2.9.1 Noise and Vibration

2.12.5 Flood Risk

Drawing Title: **FIGURE 13.19 SCHEME HIGHWAY DRAINAGE - PLAN**

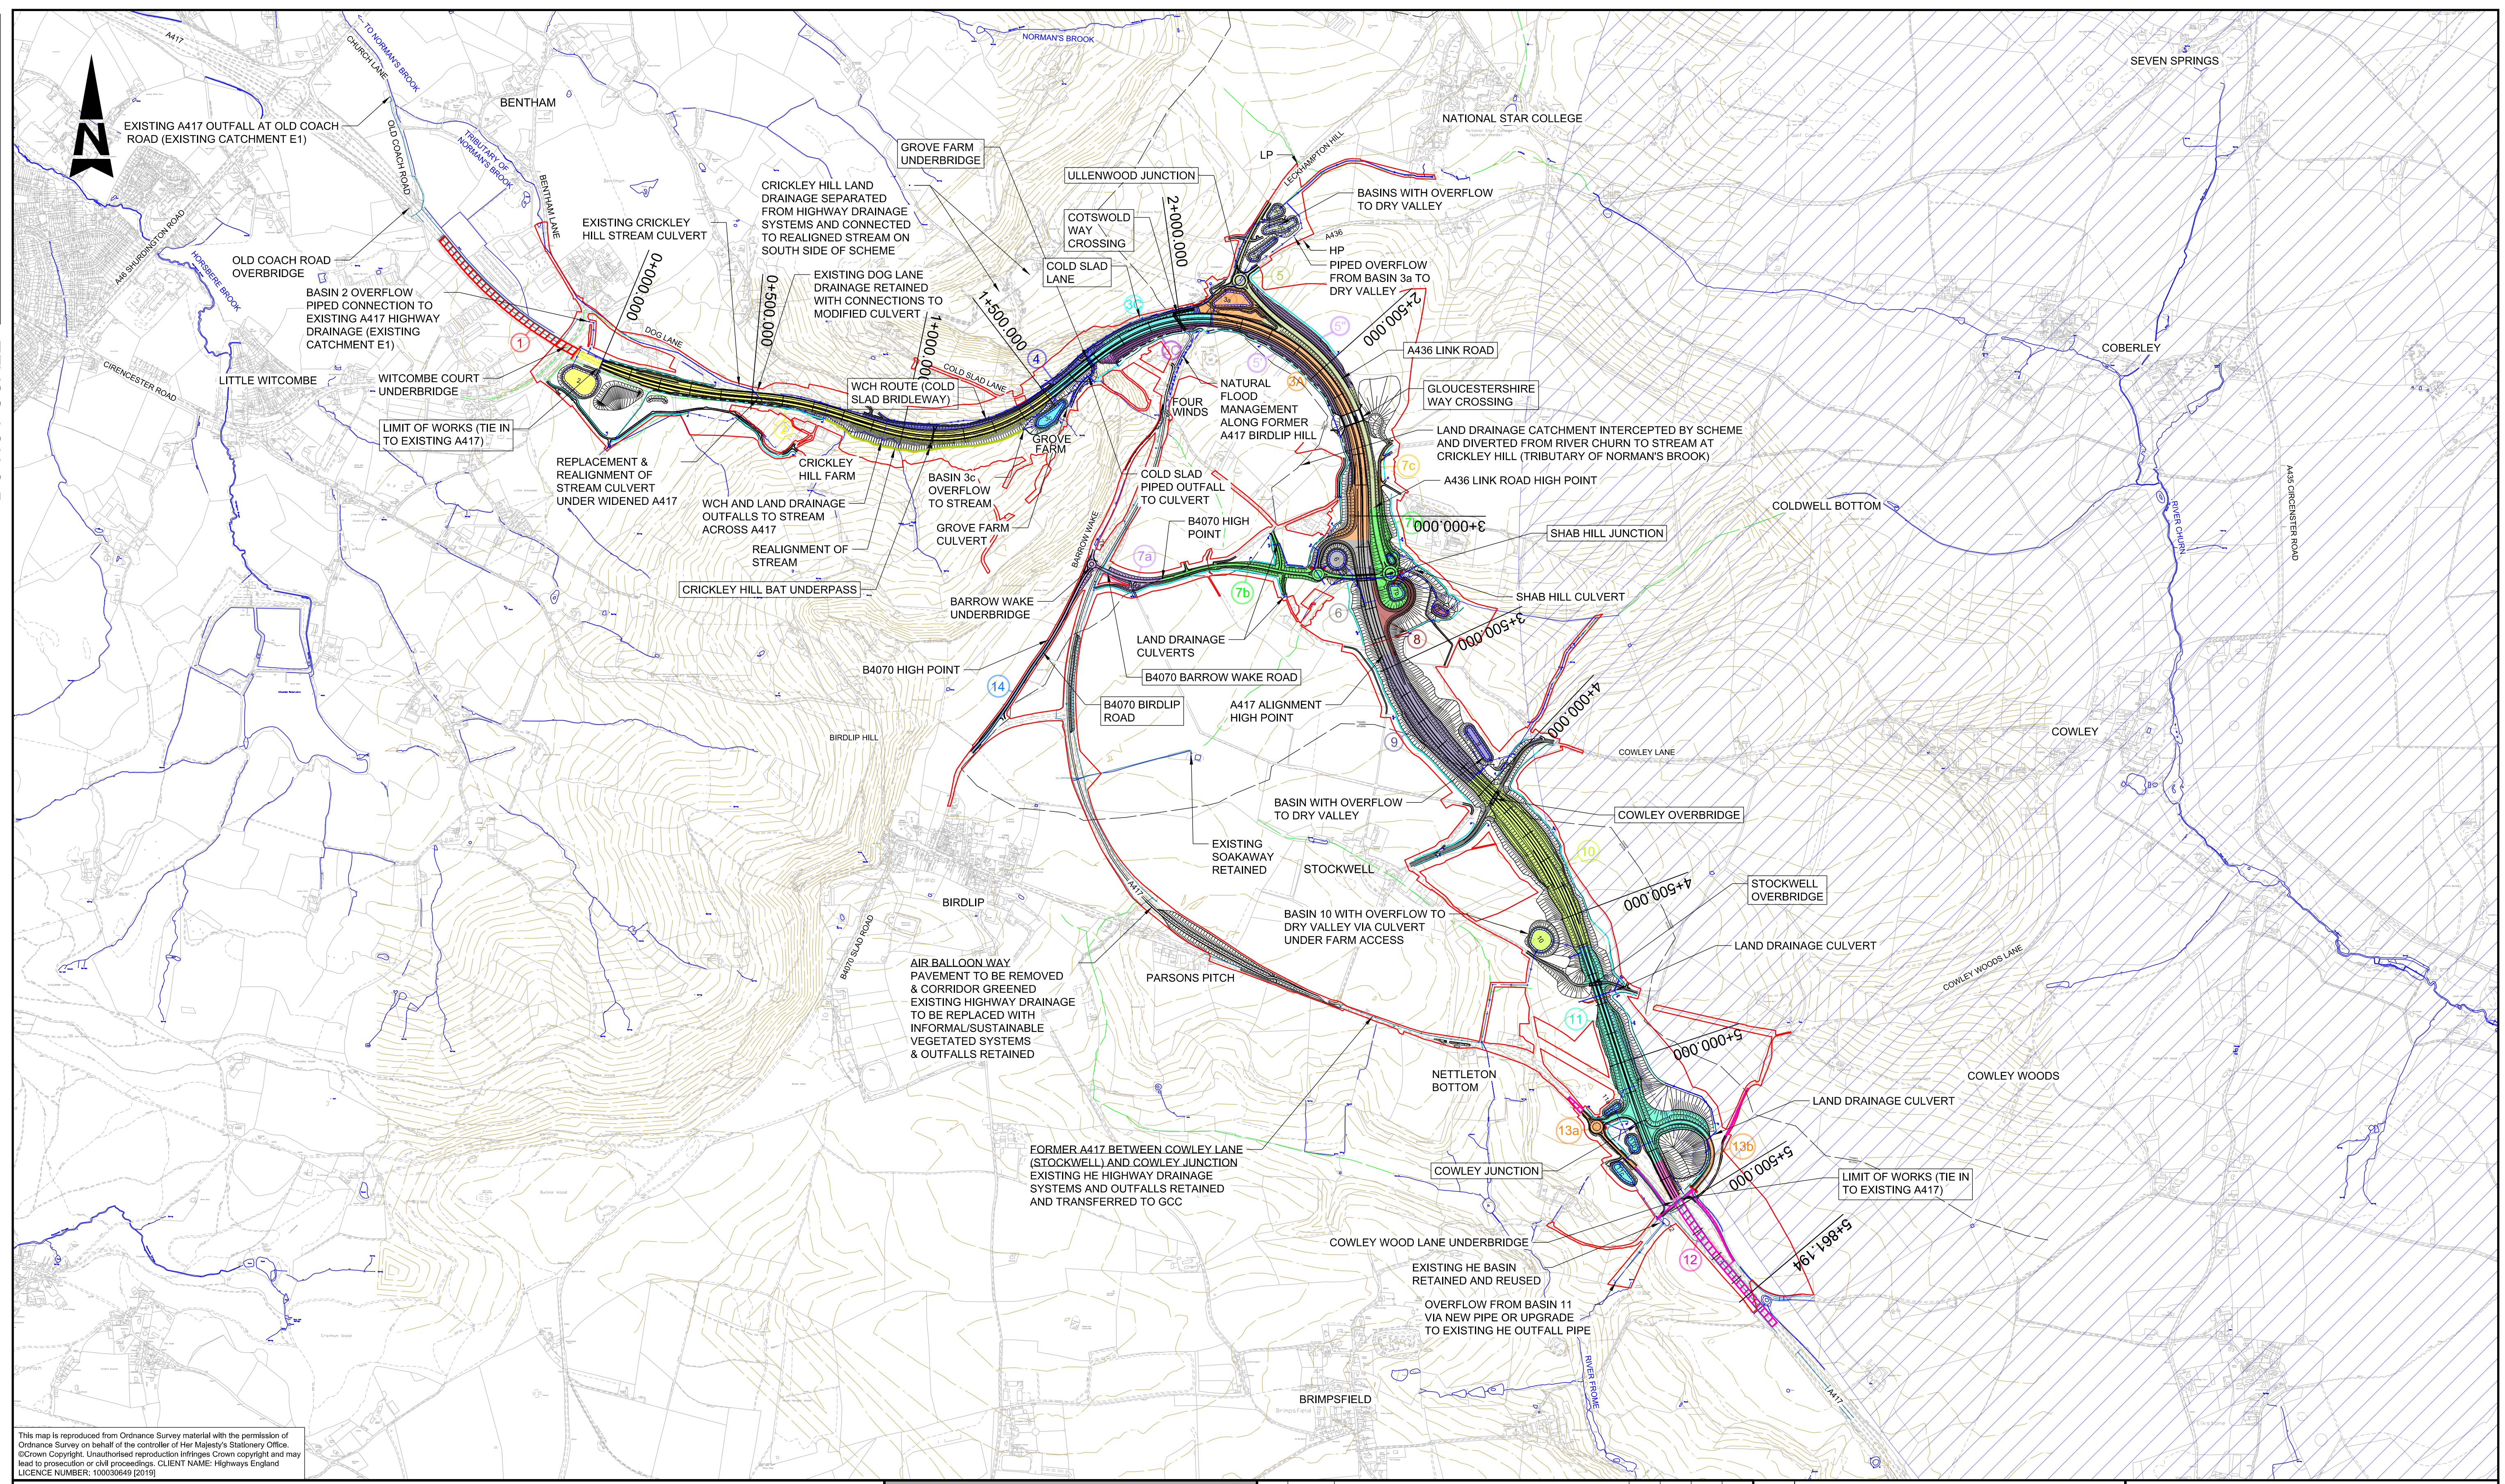
NS remain concerned at the potential flooding risks and need for the temporary drainage easement across the land from Point 1 to Point 3 as shown on the below plan. Point 3 is a natural pinch point in the field basin shown yellow.

During the course of the works, there is a proposed drainage pipe to be laid to extend from the attenuation ponds to the Point 3. This is of concern to NS, during a heavy rain event, the area shaded yellow is approximately 14 Ha and will act as the natural catchment and drain in the normal way to Point 3. The concern is that there could also be water draining from the construction site, which is being fast tracked to Point 3.

It is felt the existing drainage channels, ditches and pipe network after Point 3 are not adequate for any additional water flow directed by the new outfall. On regular occasion during the winter the carpark and access road between Point 4 and Point 5, see below photos. This route provides access to the campus and golf course and needs to be passable to provide emergency access should the main access be blocked for any reason. Therefore, any increased in flooding of the road not only causes access issues for the college, but also potentially increase damage to the road, car park and golf course.

The NS are of the opinion that there is no need for the temporary easement/drainage pipe at all. It has been agreed that the permanent drainage easement will not be required as any outflow from the attenuation ponds can be dealt with by infiltration. The college are currently waiting for a letter from National Highways confirming this. Why can't the works discharge any overflow water into the field shaded yellow at Point 1? This will allow for the field to carry out its natural drainage cycle to delay water through infiltration within the natural field drainage as shown in the photo above at Point 2. This will create lag time, delaying the water reaching the pinch point at Point 3. Any flooding will be of existing wet grassland and not an access road or golf course.

In summary, NS believe the addition of any new drainage conduit which fast tracks water from the head of the valley is not necessary and potentially a flood risk.
